TfNSW reference: REN25/00086/005

Your reference: SSD-72430958

**SSD-72430958, Finley Battery Energy Storage System - Various Lots, Berrigan Shire Council;
Response to Submissions**

This attachment relates to TfNSW's response dated 2 April 2026 reference REN25/00086/005.

Prime mover and semi-trailer (19 m)  
 Overall Length 19.000m  
 Overall Width 2.500m  
 Overall Body Height 4.300m  
 Min Body Ground Clearance 0.540m  
 Track Width 2.500m  
 Lock-to-lock time 6.00s  
 Curb to Curb Turning Radius 12.500m

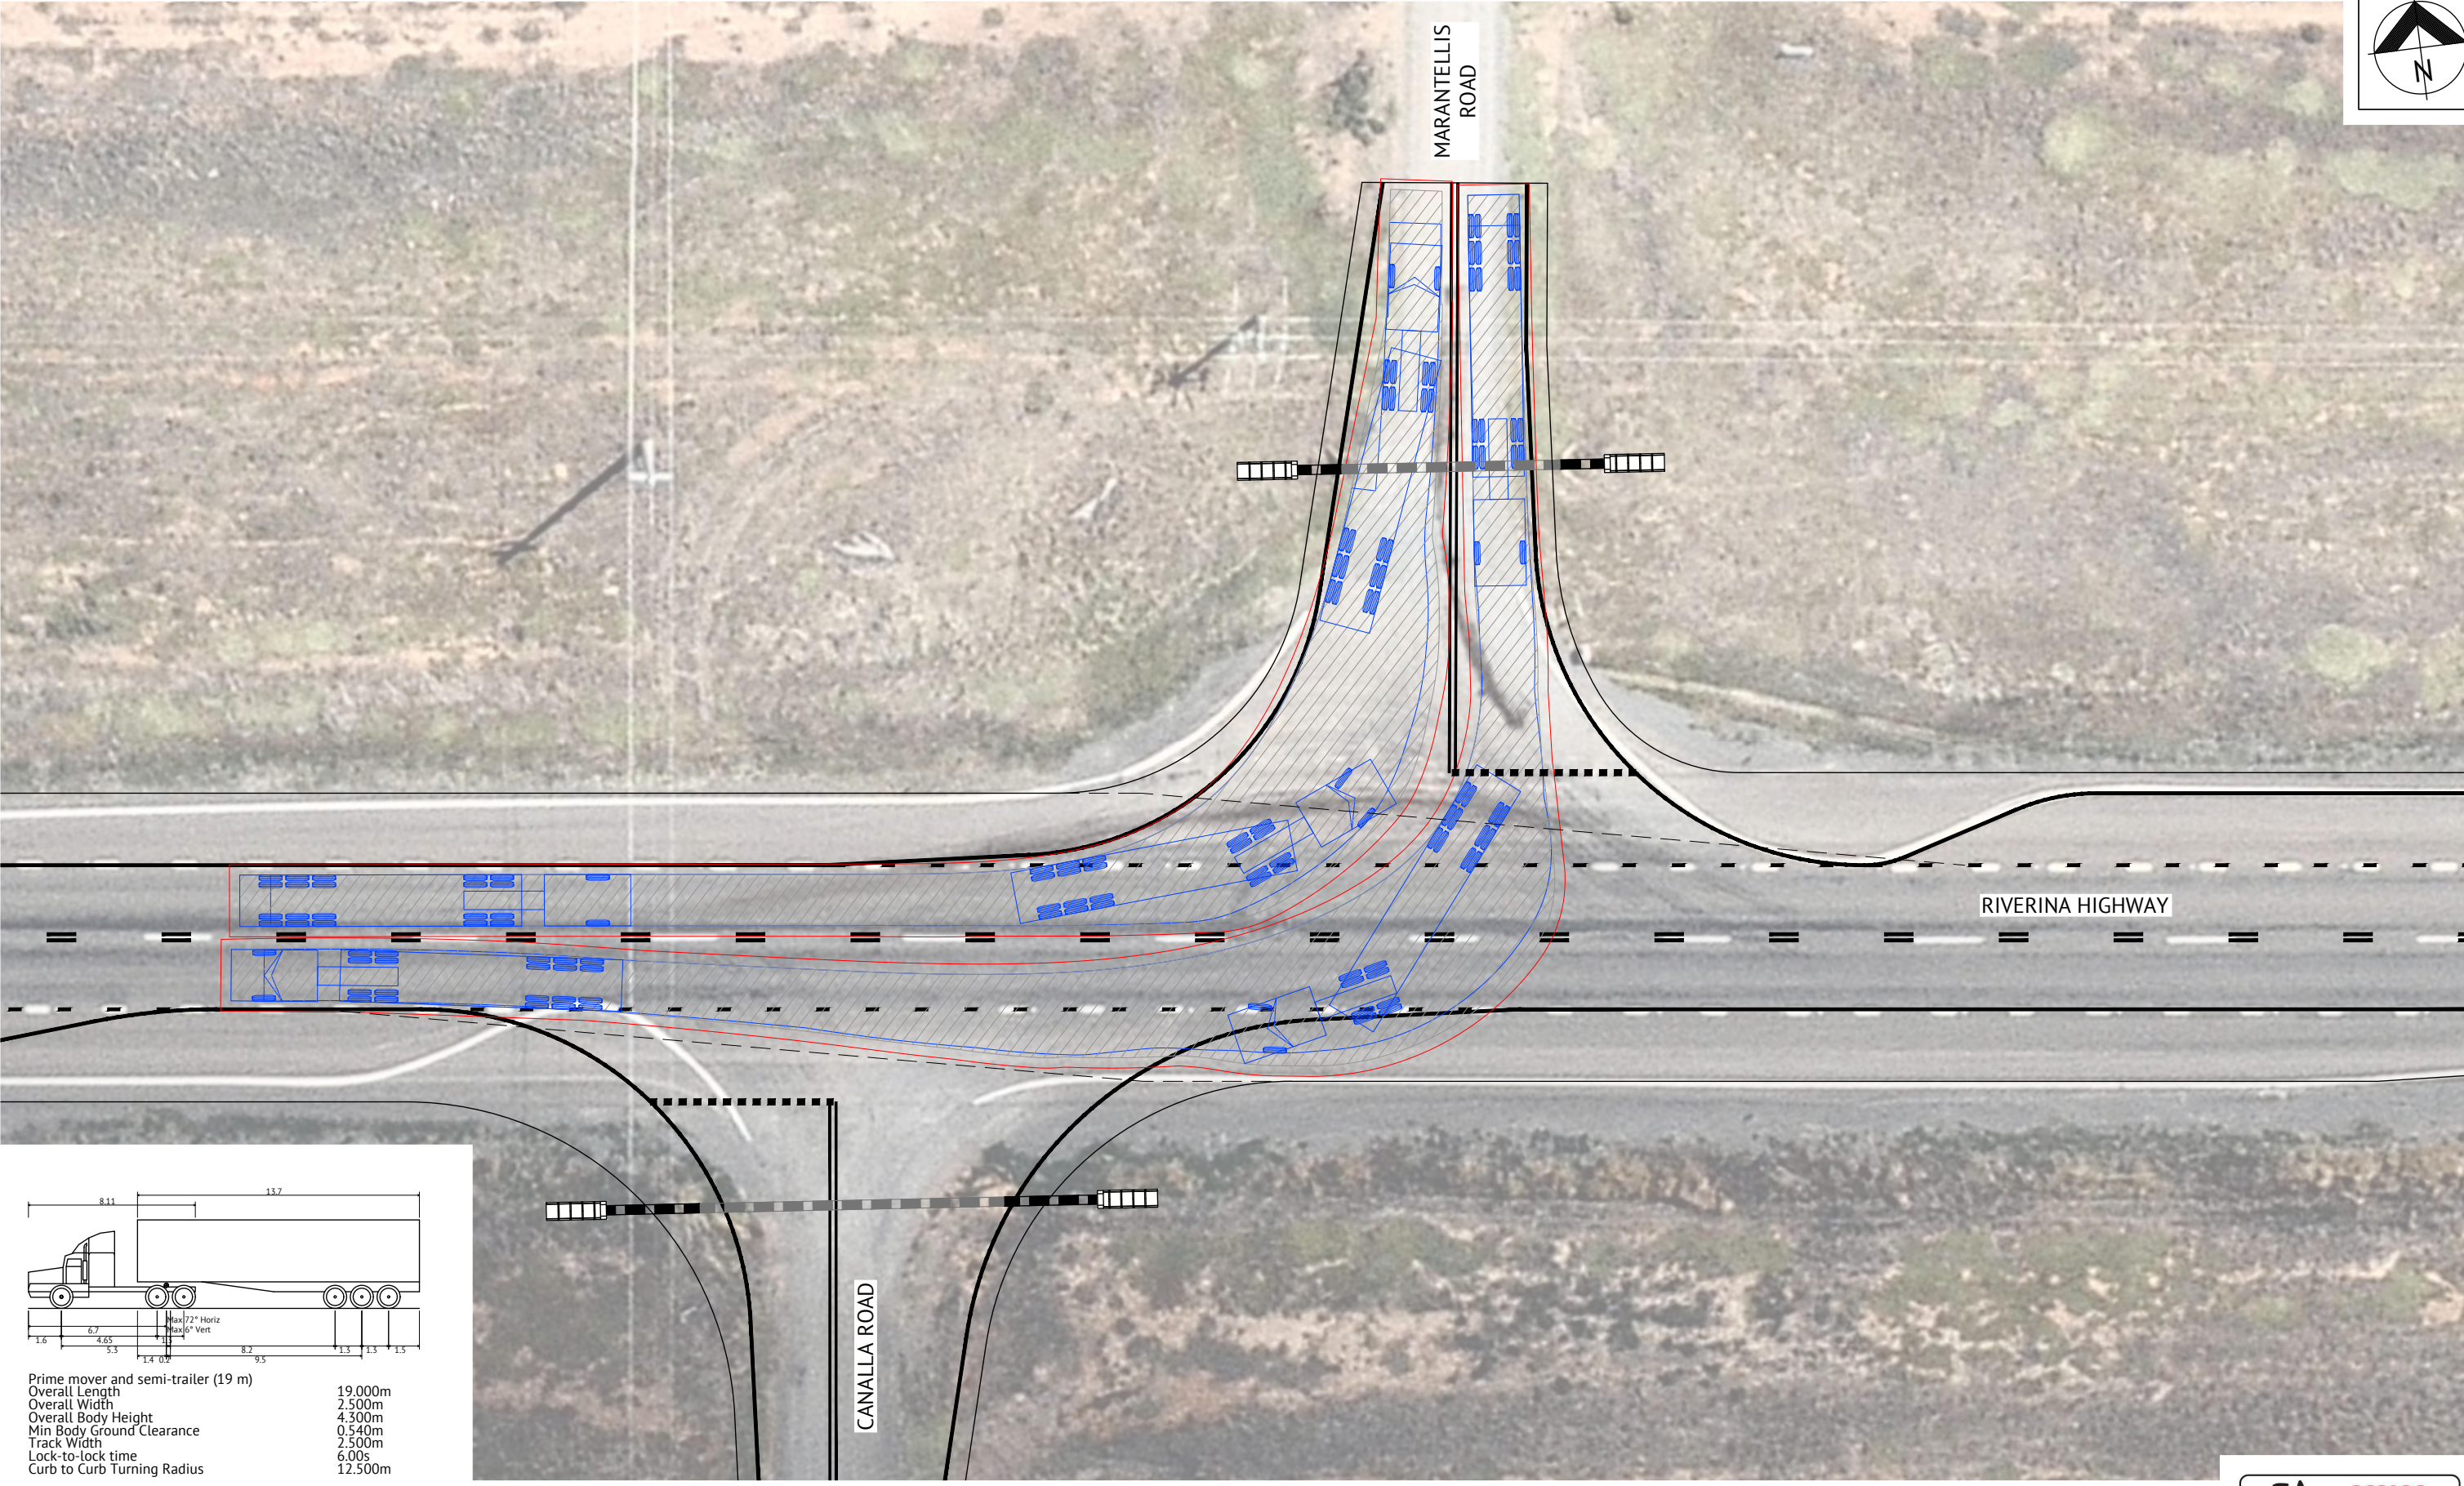
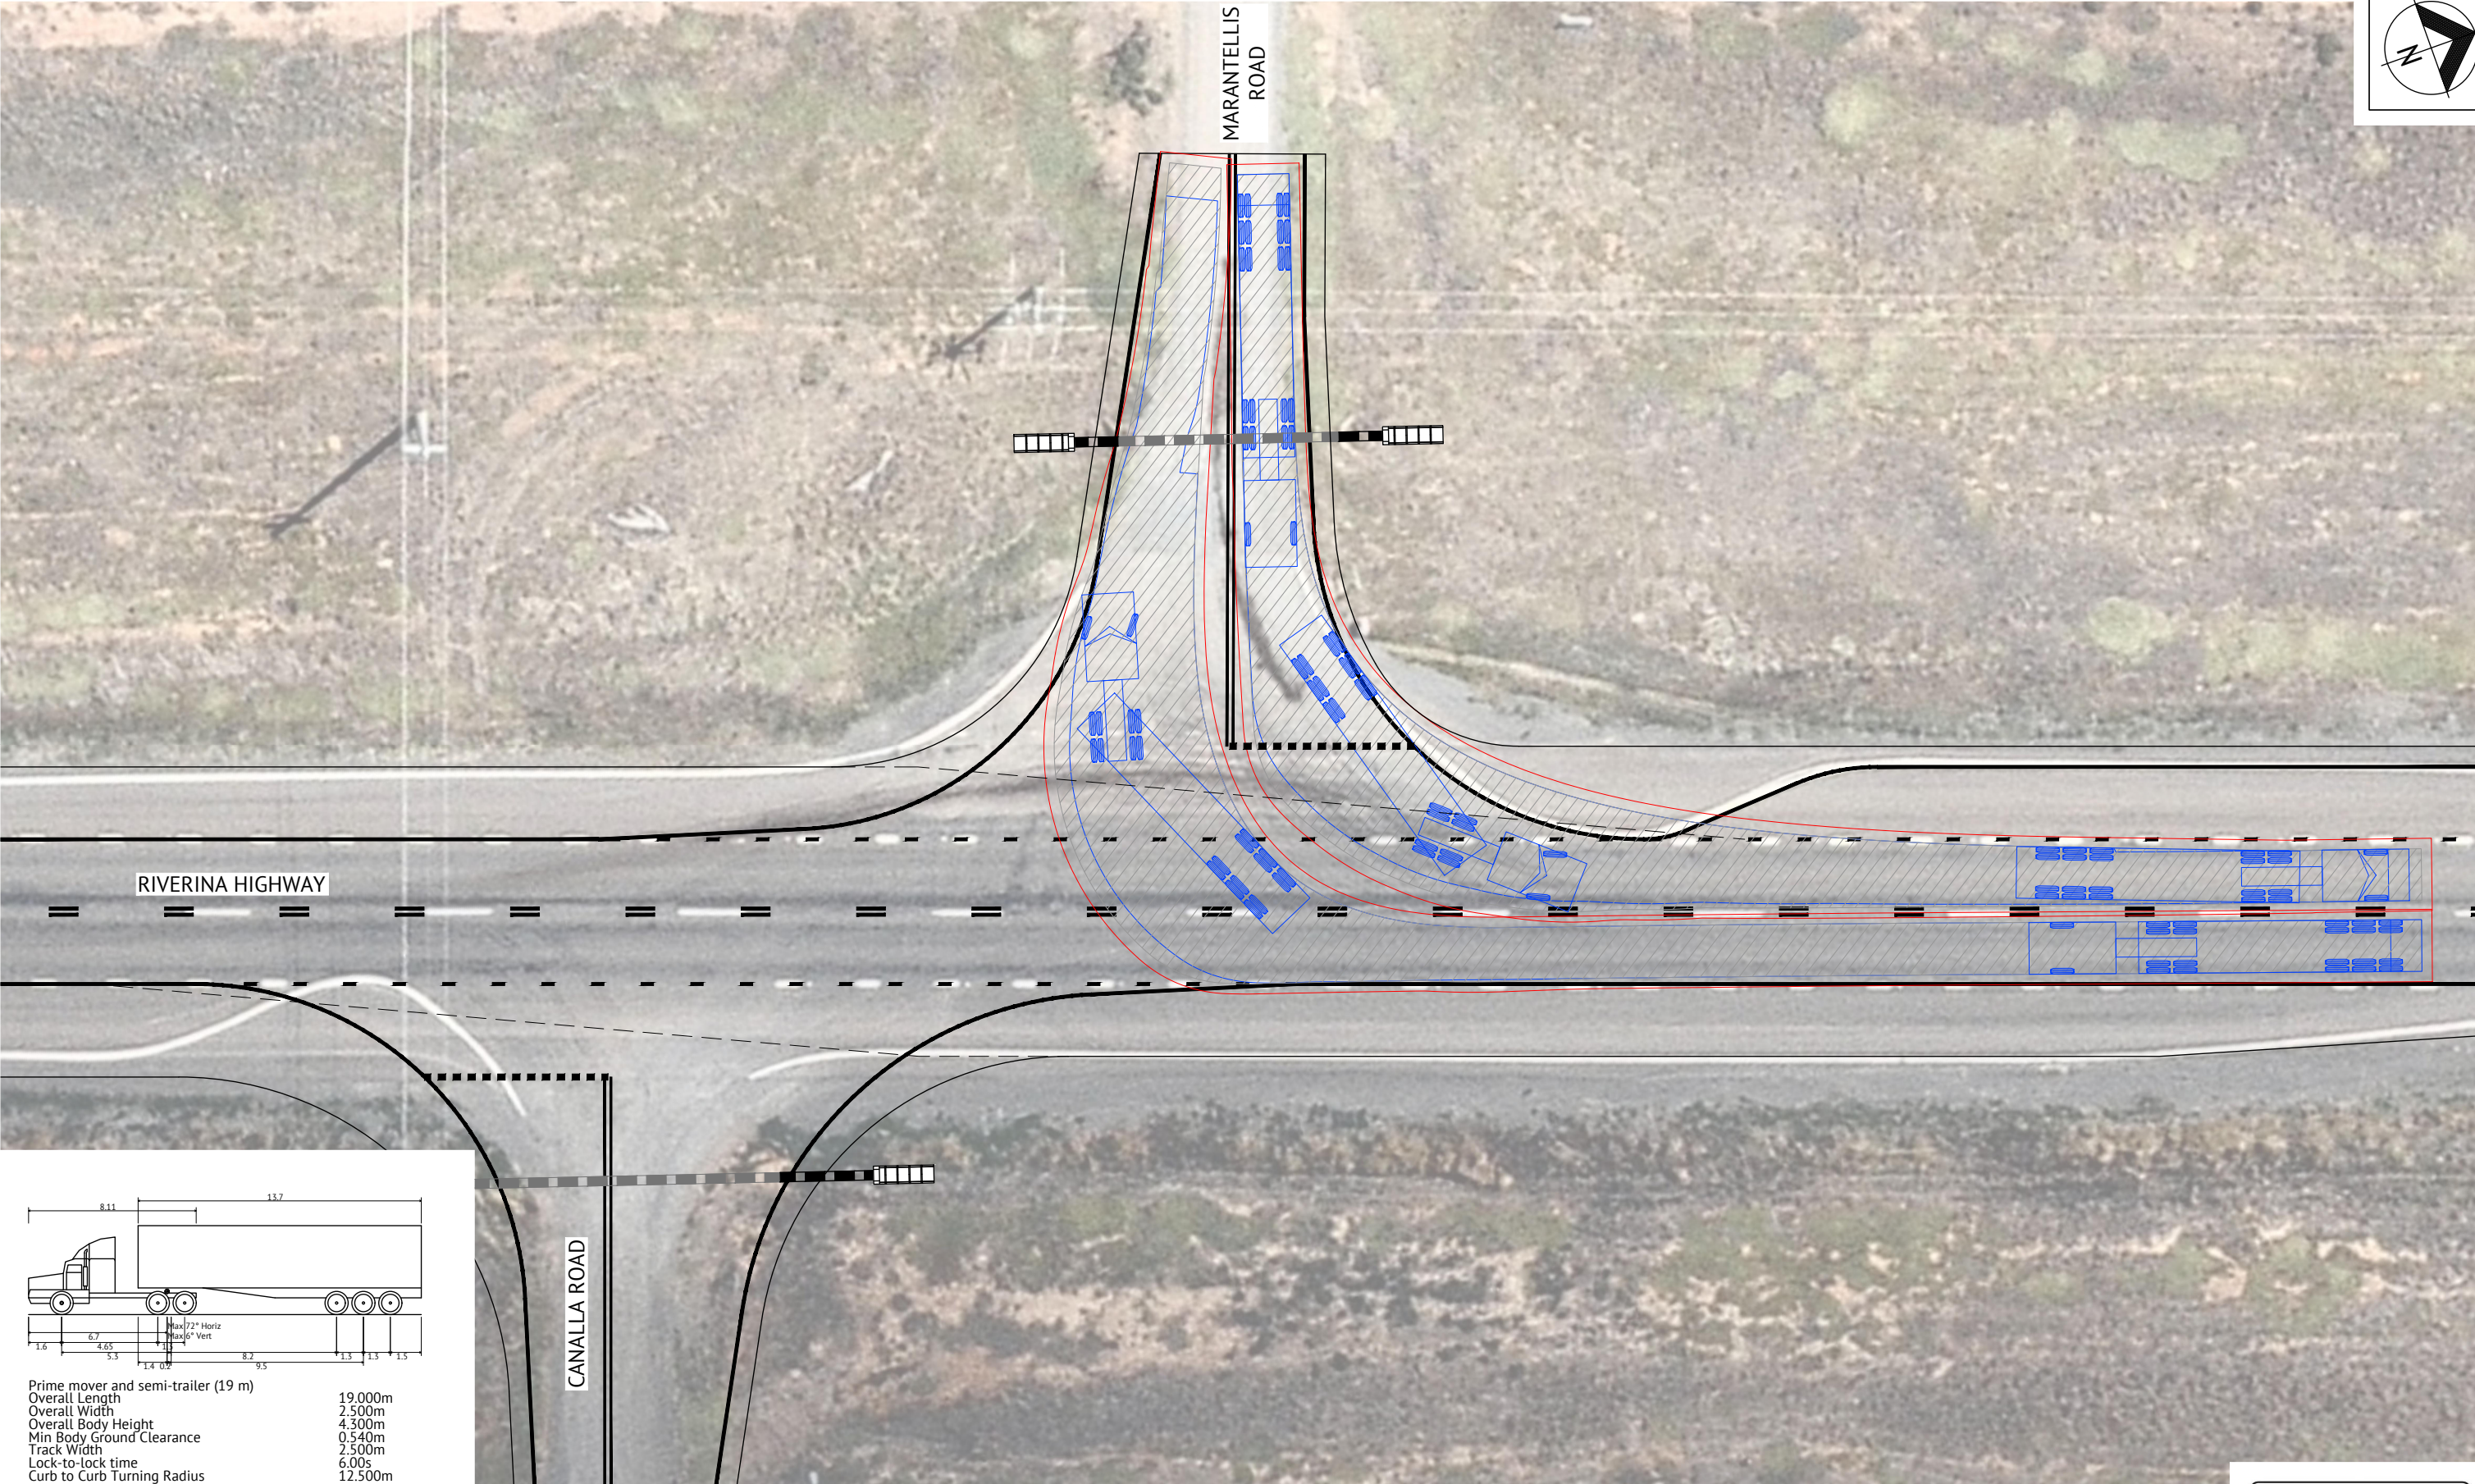
d) Swept Paths Swept paths are required to be provided for the largest heavy vehicle and high-risk OSOM configuration (corresponding to the design and check vehicle) required to use each intersection, access point or navigate pinch points along the high-risk OSOM routes. This must be prepared following Austroads Design Vehicles and Turning Path Templates.	OPEN - The swept path still shows a right-turn movement crossing the Canalla Road centreline. Revise the swept path analysis and consider traffic mitigations to manage the impact to avoid crossing the centreline of Canalla Road. If traffic mitigation measures (i.e., limiting the use of the intersection for construction traffic to one heavy vehicle at a time, turn prohibitions or reduced design vehicle size). The implementation of traffic mitigation measures, enforceability and compliance must be discussed with DPHI to determine the suitability of the proposed measures. If DPHI determines that the proposed traffic management measures are not enforceable, the intersection will need to be widened to accommodate concurrent turn movements within the pavement, without requiring crossing the centreline of Canalla Road.
